Submission on the Visual Impact of the ICC Convention on Goldsbrough Apartments

Conybeare Morrison International Pty Ltd (CM+) has been commissioned by The Goldsbrough Apartments to prepare a report assessment on the impact of the proposed Sydney International Convention Centre on the loss of views due to its bulk and height, on the residents of the Goldsbrough Apartments. Redevelopment of Sydney International Convention, Exhibition and Entertainment Precinct is being assessed as a State Significant Development Application under Part 4 of the EP&A Act and SEPP *State and Regional Development 2011*.

ICC CONVENTION

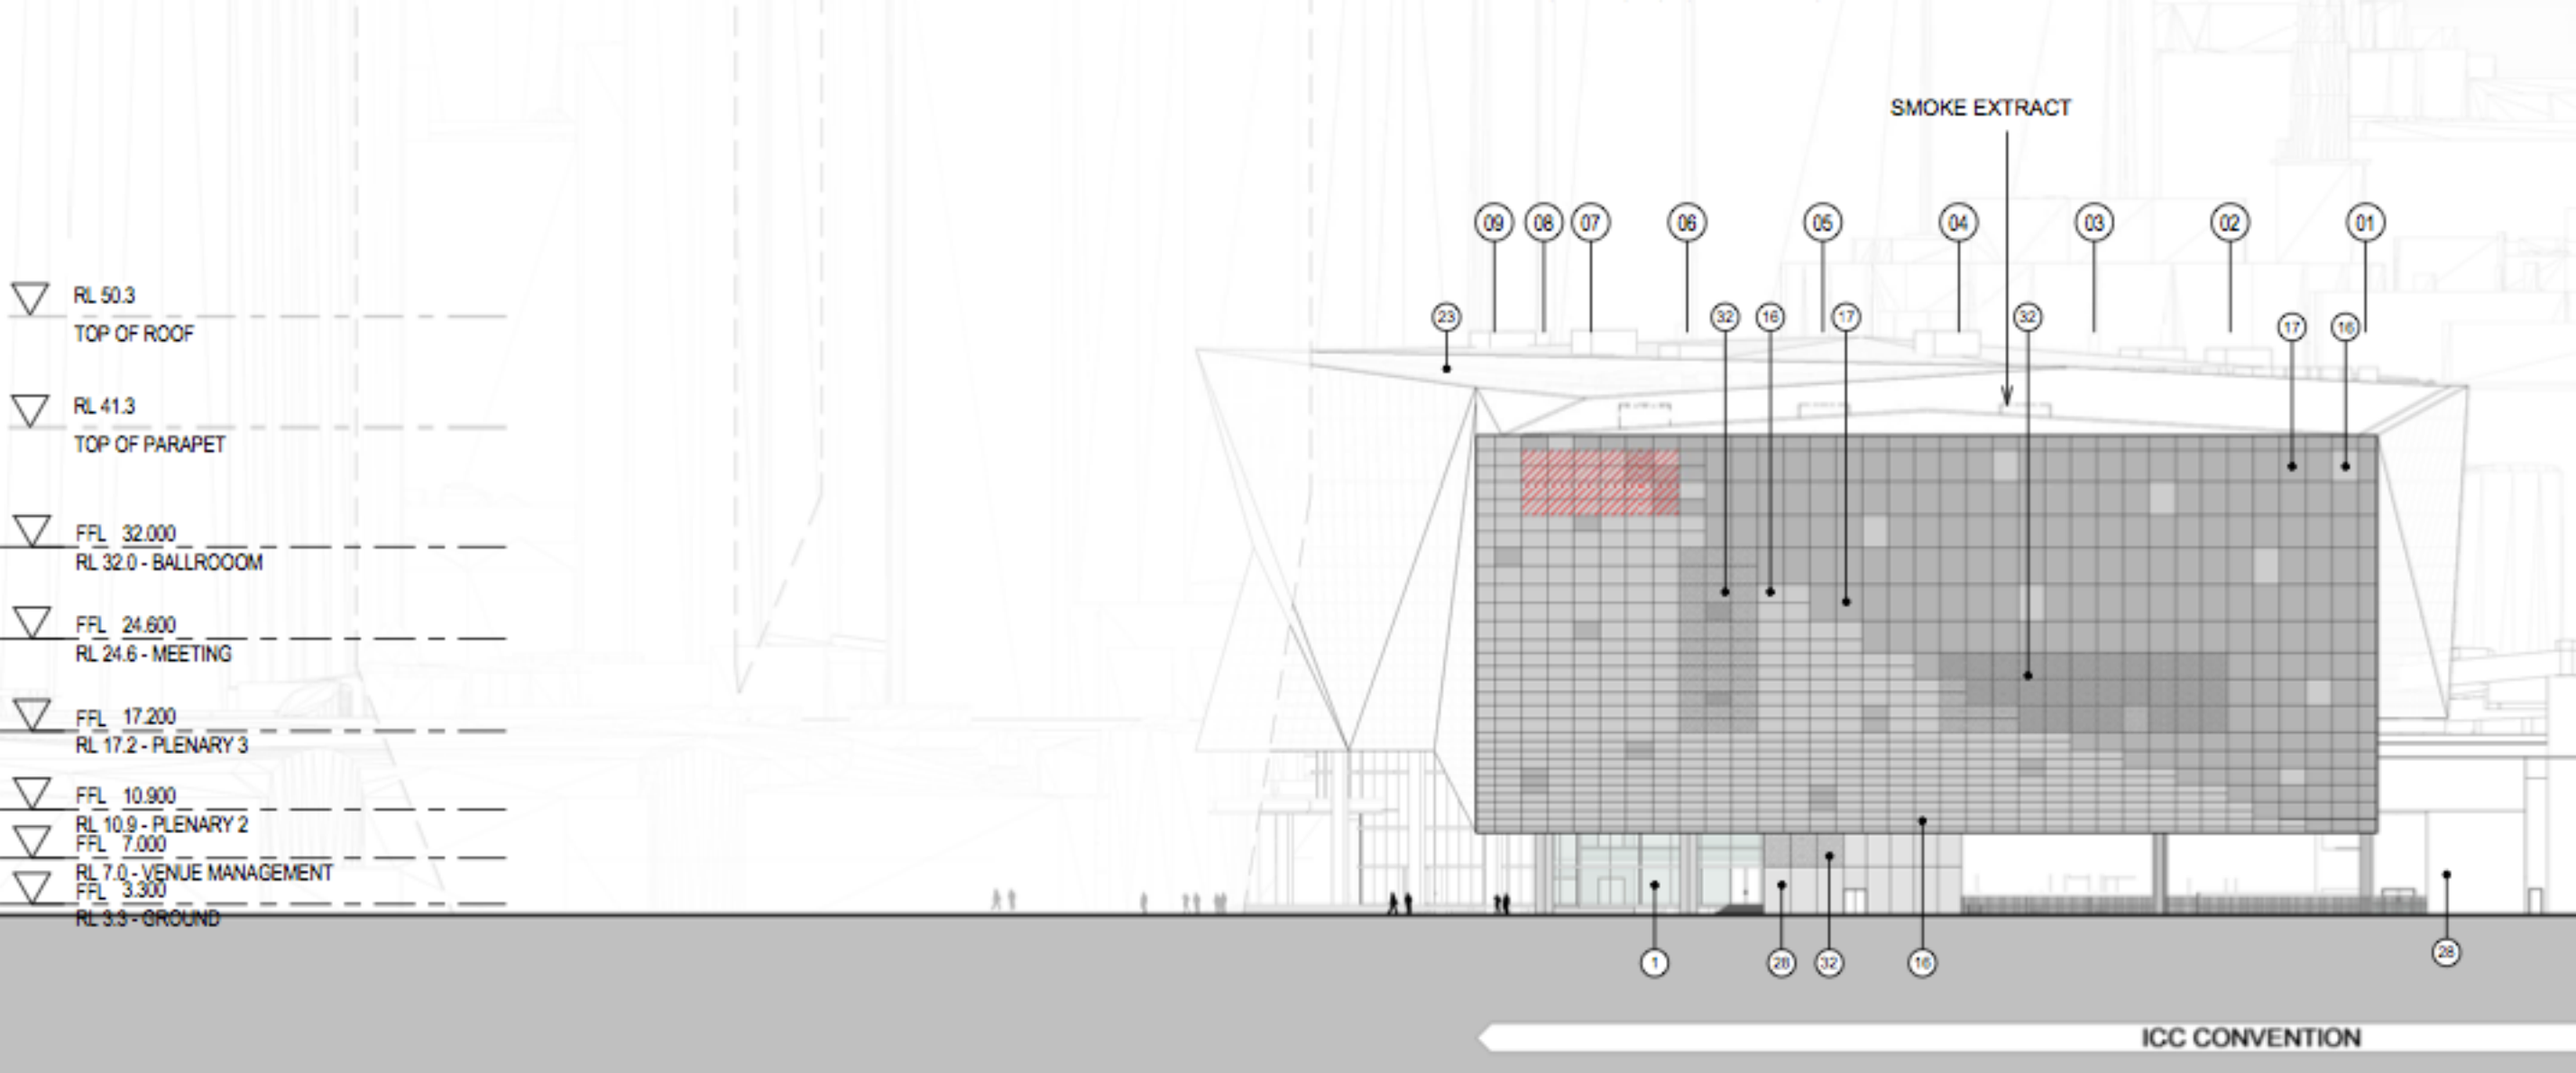
To compare the height of the proposed ICC development with the existing Convention Centre, the building heights of the existing SCEC buildings are up to approx. RL 22 AHD (p.19, EIS). The proposed Convention Centre with roof height (not parapet height) up to RL 50.30 is approximately **28.3m higher** than the existing Convention Centre.

Figure 12: Section through the ICC Convention and its impact on views from Goldsbrough
 (source: Architectural drawing – PP_AR_2033(A))

These views, **directly to the east**, will be removed or reduced (from **Levels 5–8**) with the construction of the ICC Convention, with its proposed uppermost roofline approximately 25m (at RL 50.30) above the existing Convention Centre and its western parapet approximately 16m above the existing Centre (at RL 41.30).

The **design of the proposed ICC Convention should be re-evaluated**, particularly its height and bulk in relation to the context of its siting at the Cockle Bay foreshore. The proposed ICC Convention **fails to**:
